**Consultation Response from KC,
Trees****2024/90769 adj, 27, Riley Park, Kirkburton, Huddersfield, HD8 0SA****Erection of one detached dwelling and associated works****Date Responded: 30/04/2024****Responding Officer: D. Atkinson****Responding Ref: CA15**

3106-005

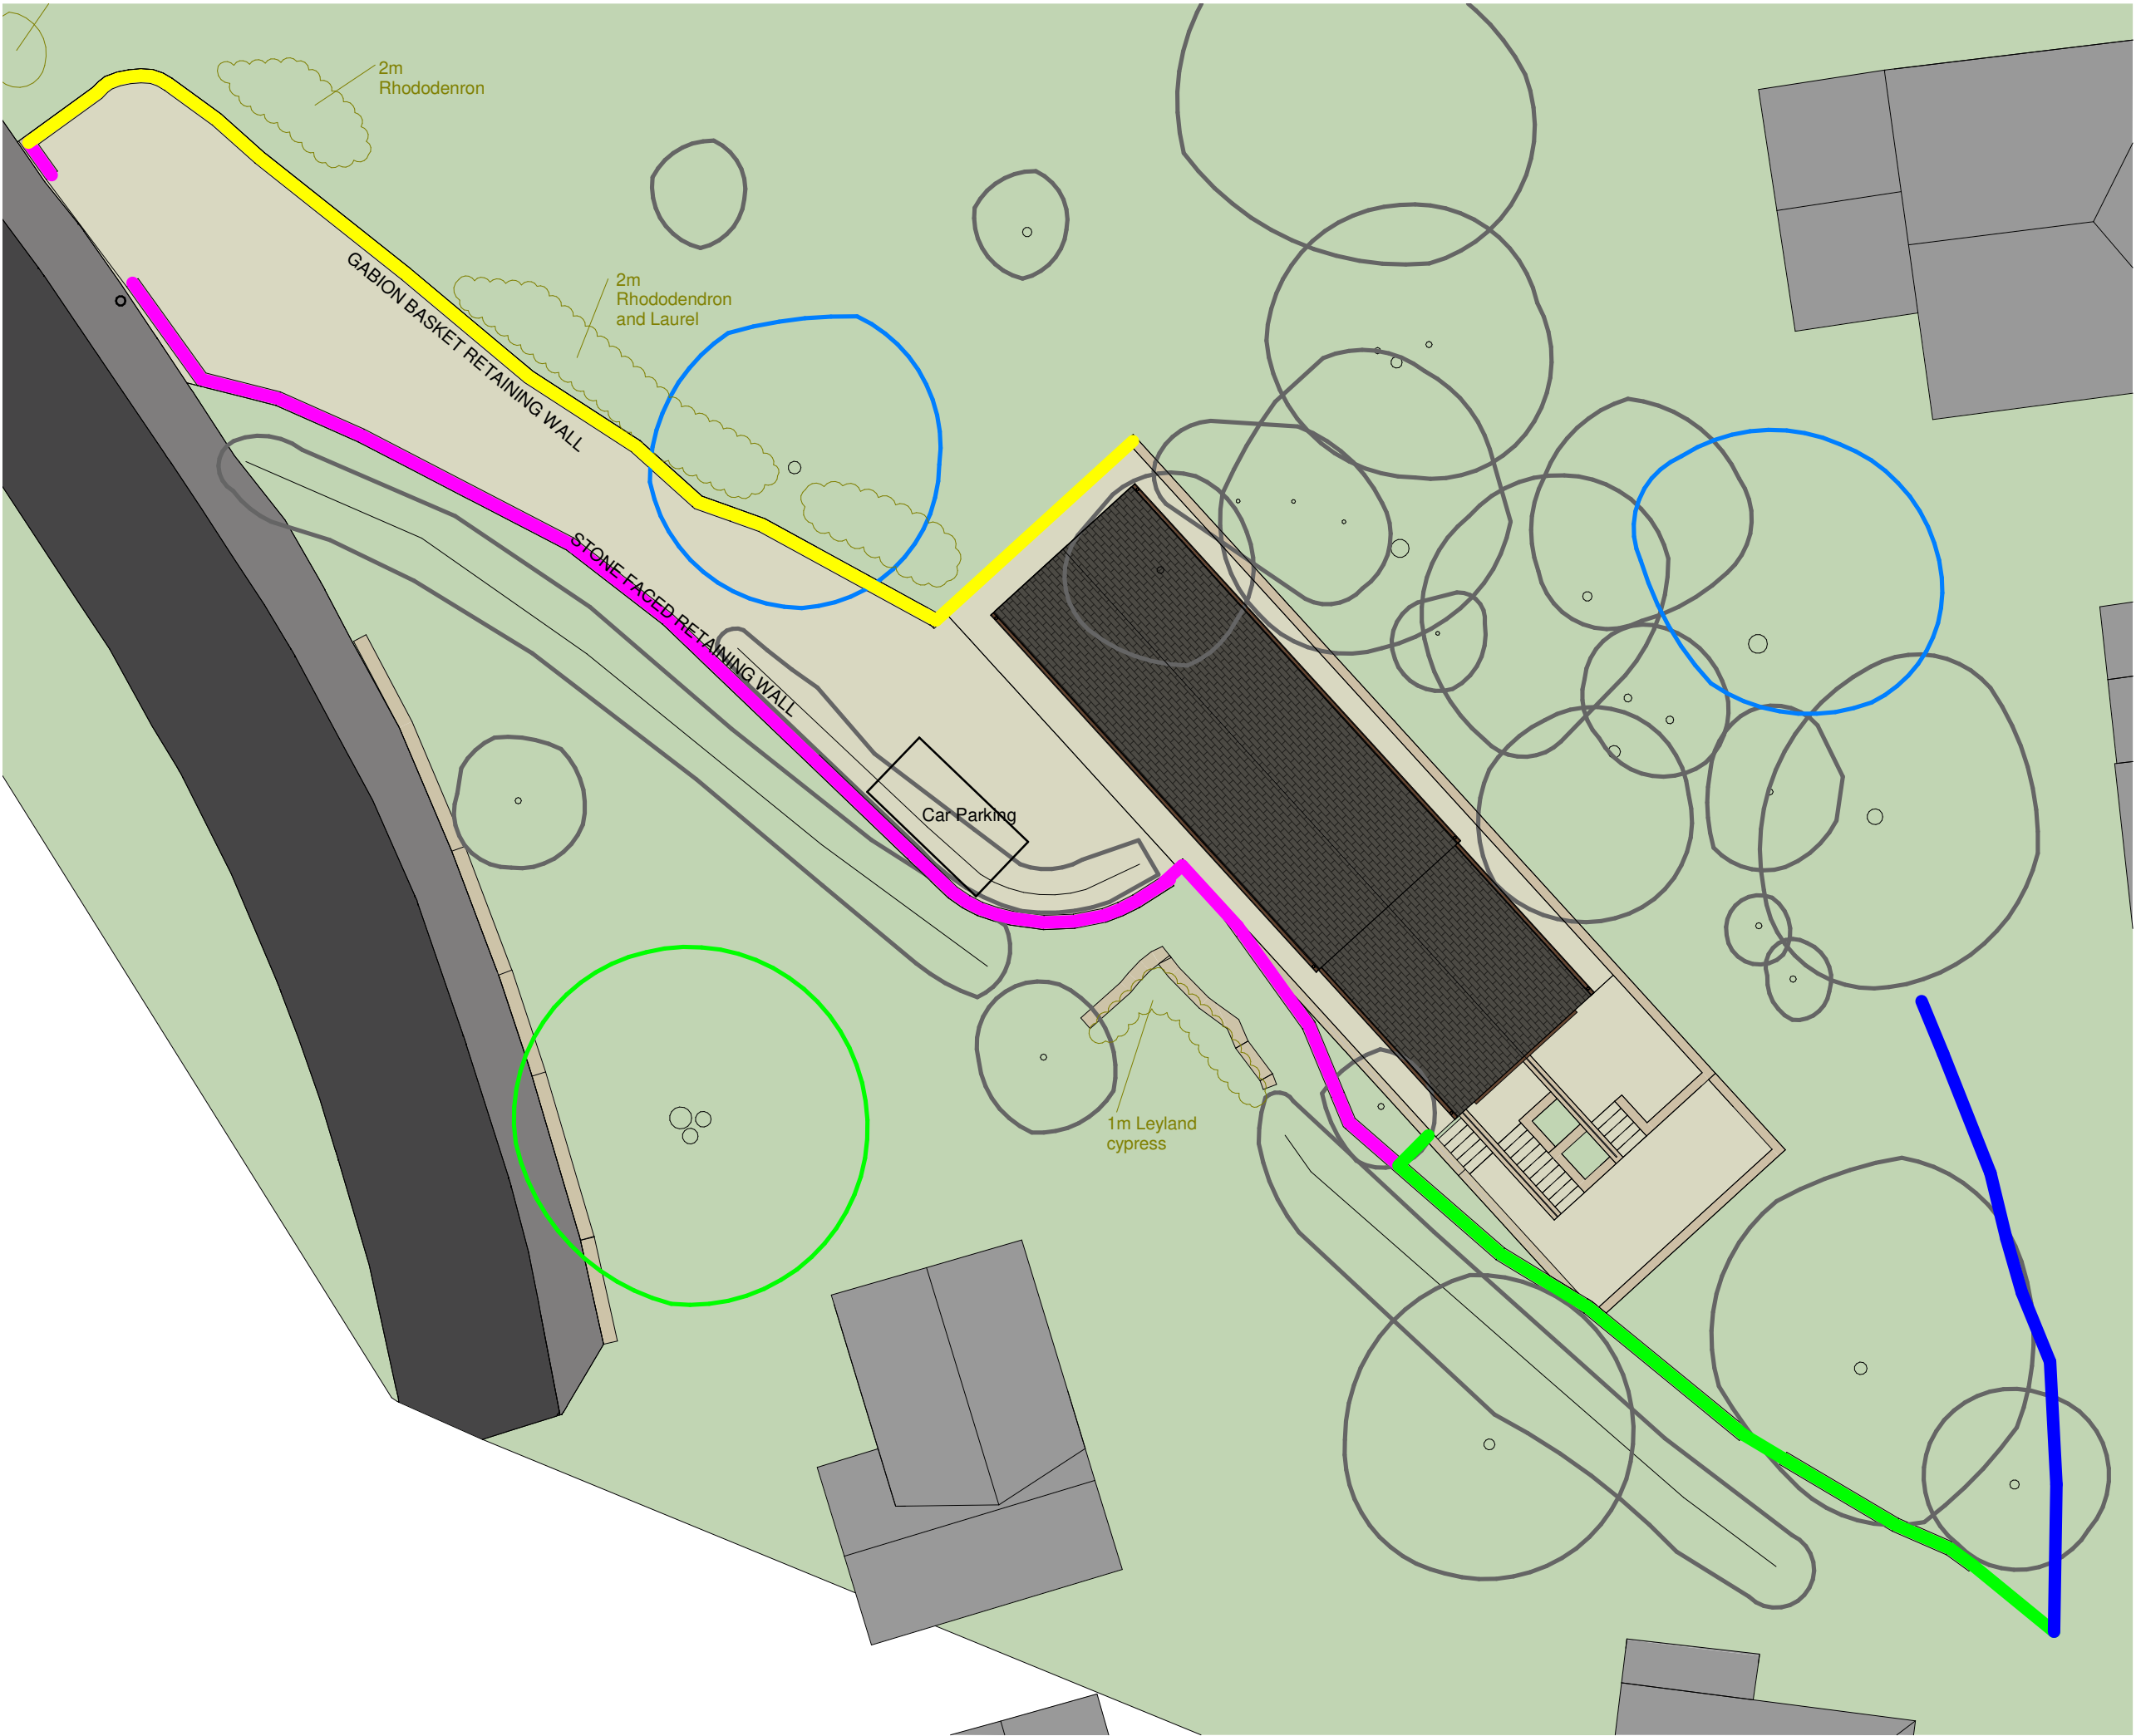
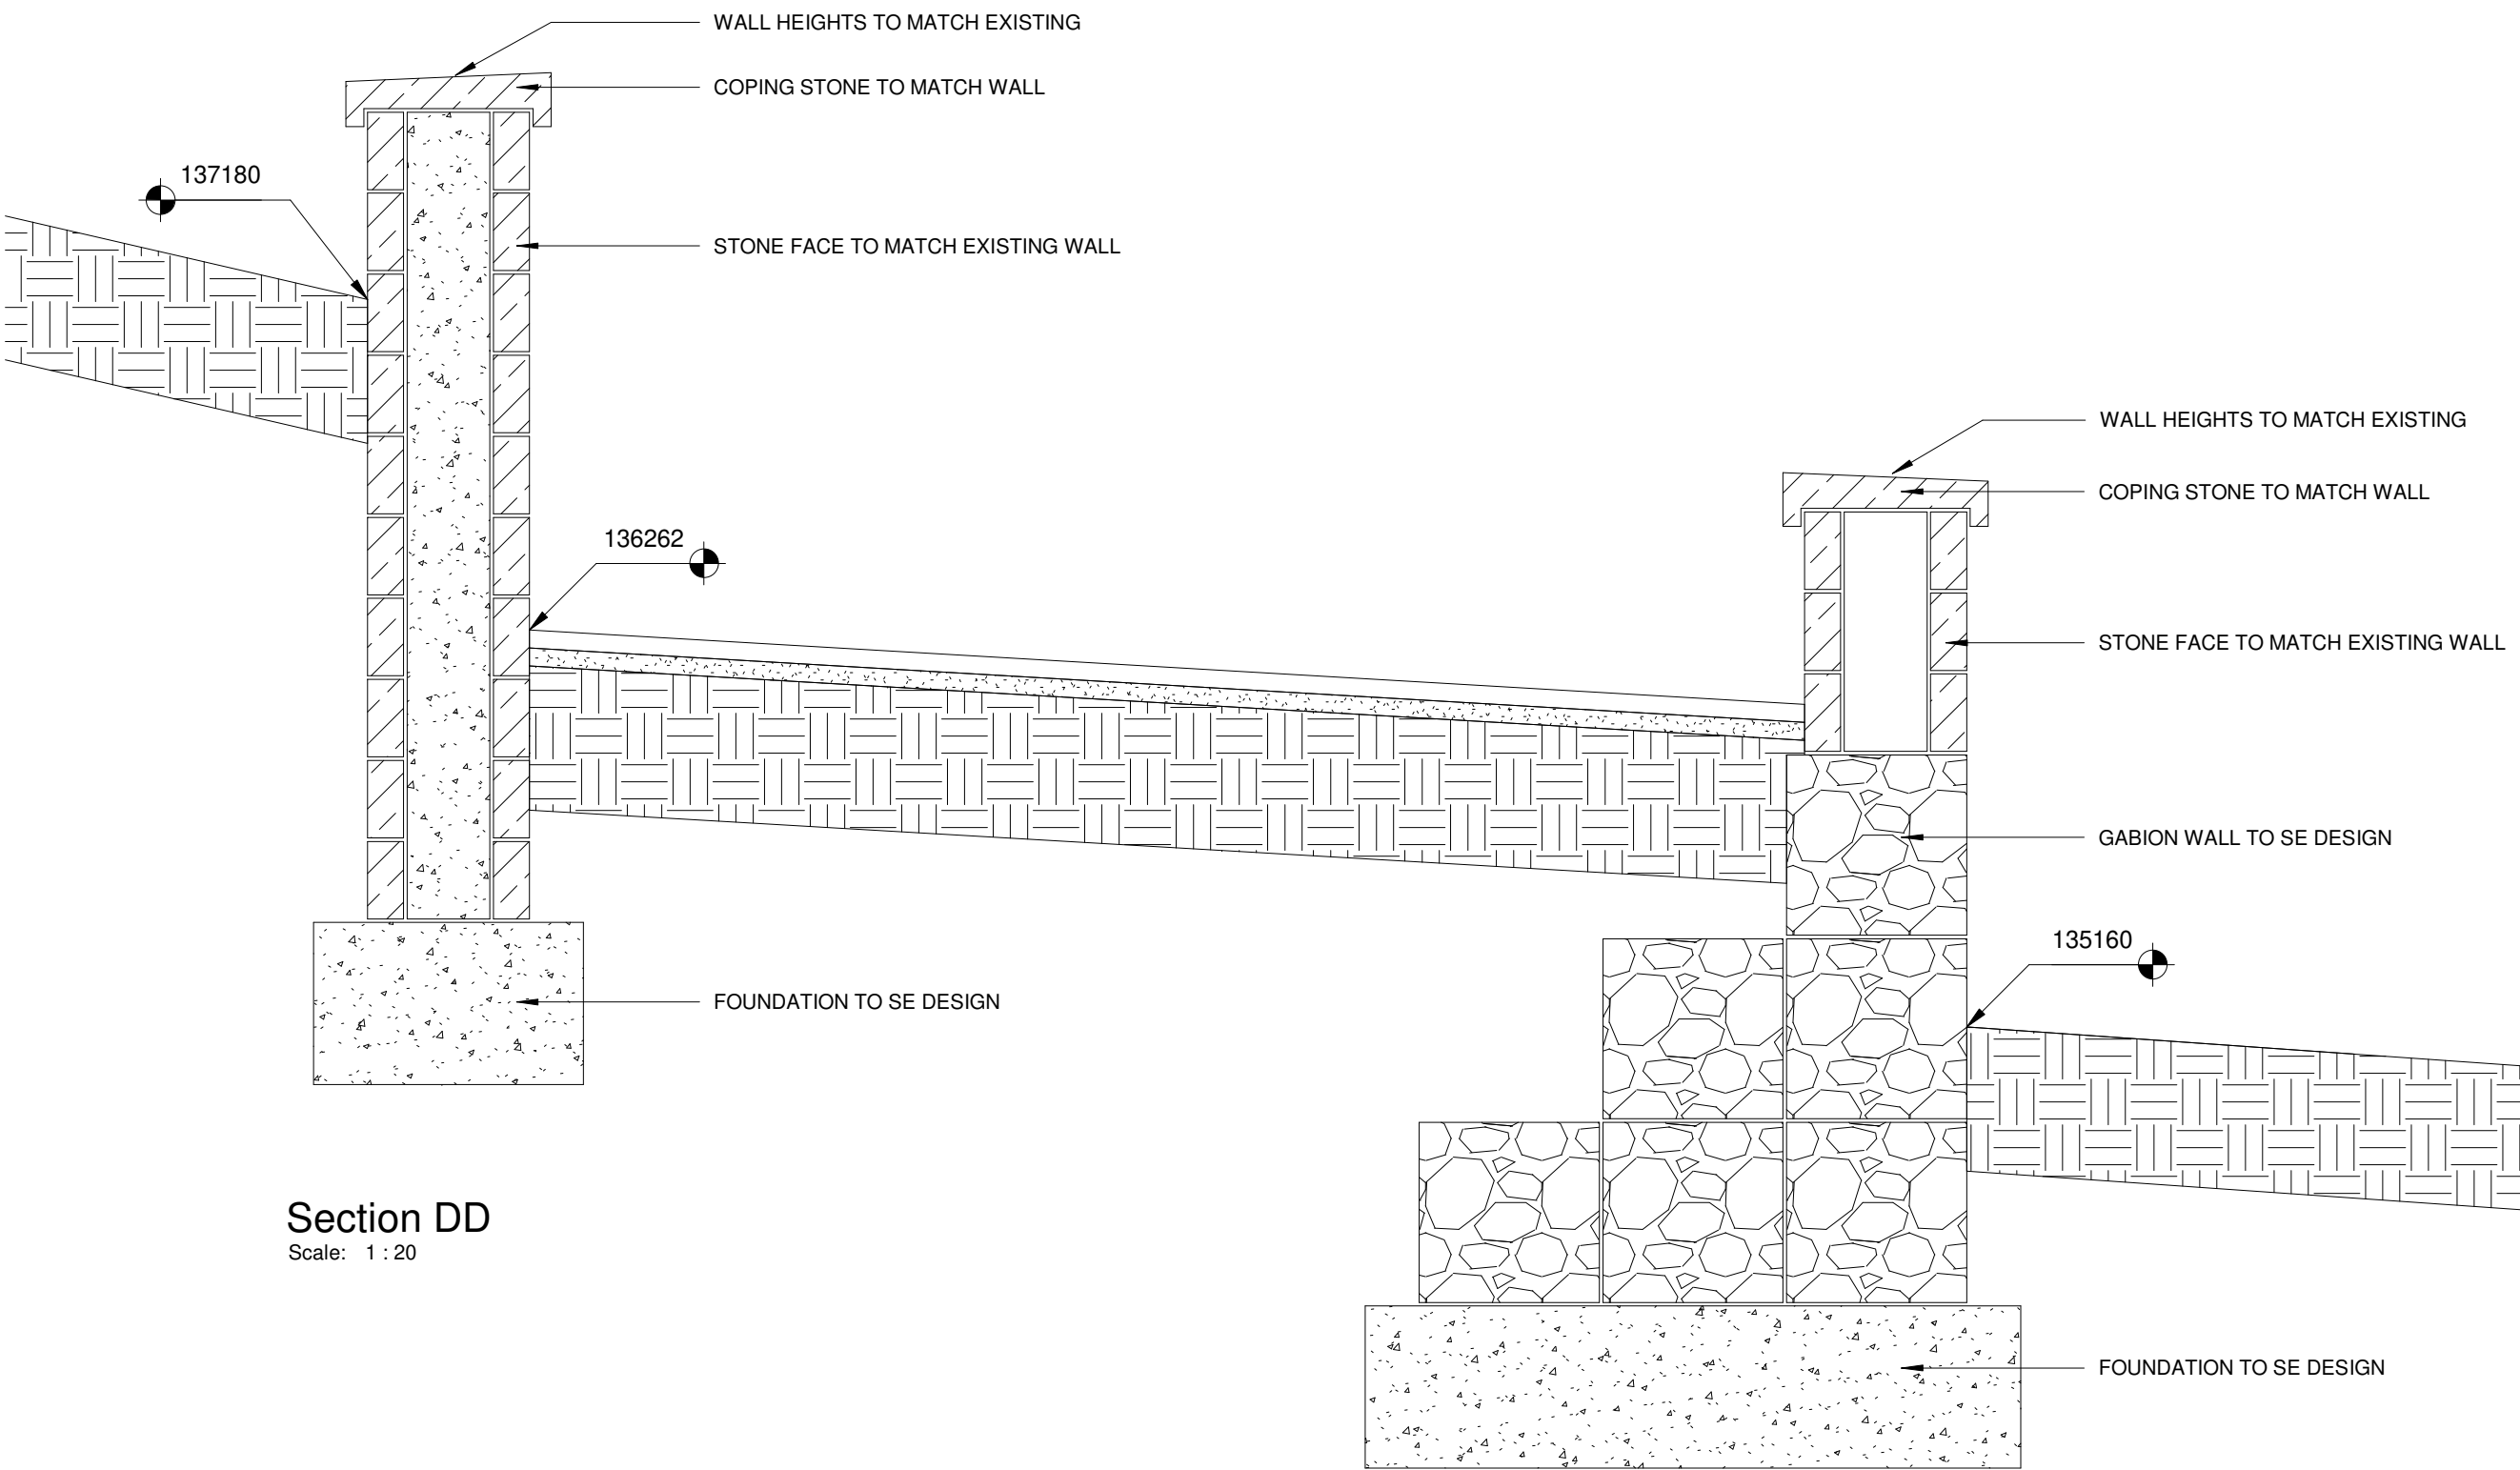
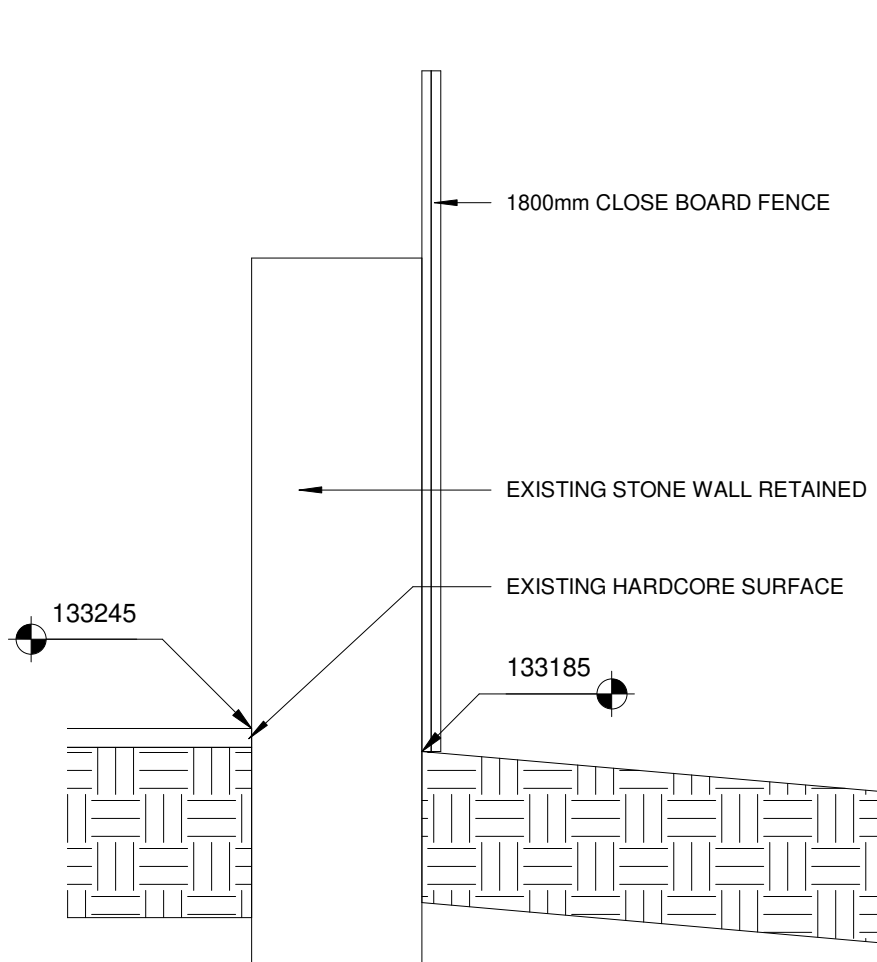
From drawing 3106-005, the construction appears to significantly encroach into the RPA of the Cedar (T3).
